Planning Officer: Mr F Gardner
Planning Application Ref: LU/150/19/T
Location: Apple Tree Cottage, Toddington Lane, Littlehampton, BN17 6JX
Description of works: Fell 1no. Robinia & reduce crown of 1no. holm oak by 2m
Reasons Given: T1 - To encourage better form T2 – Health and safety

Apple Tree Cottage Bn17 6JX

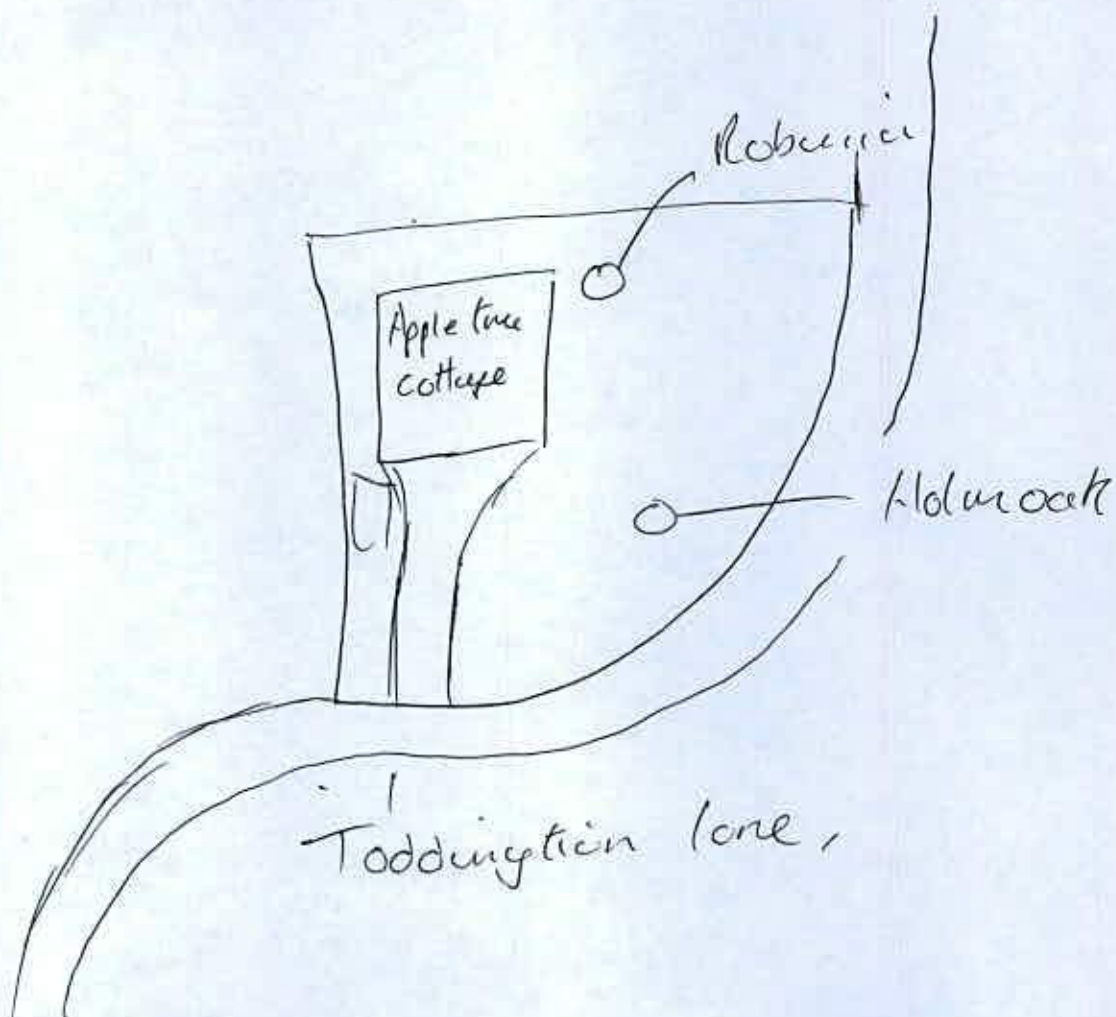
- T1 - Appears to be in a fair physiological state and of moderate form, having been previously ‘topped’ at 4metres height and with an uneven limb and branch recovery. This is clearly a tree in slow but inexorable decline and having become unsuitable for its location. It is visible from adjacent properties but only with difficulty from publicly accessible land.
- T2 – Appears to be in a fine physiological state and of moderate form, having been suppressed a little by the adjacent established large pine trees. While of some visual interest it is clearly subordinate to the pine trees which are of much greater value. A re-balancing of the crown profile is unlikely to improve the tree’s long-term prospects but would introduce some formality to this part of the garden.

- I recommend **CONSENT** for this application, subject to the following conditions:

- Where whole branches are to be removed and final cuts made close to the trunk or branch union they are to be made as shown in Figure 2 of BS3998:2010
- Where branches are to be shortened back the final cuts are to be made at the correct angle shown in BS3998:2010 and adjacent to a live bud or lateral.
- The long-term vitality of tree T2 is best respected when significant pruning work such as proposed, is undertaken during the mid to late-winter period (January to February). The work proposed must only be undertaken during this period.
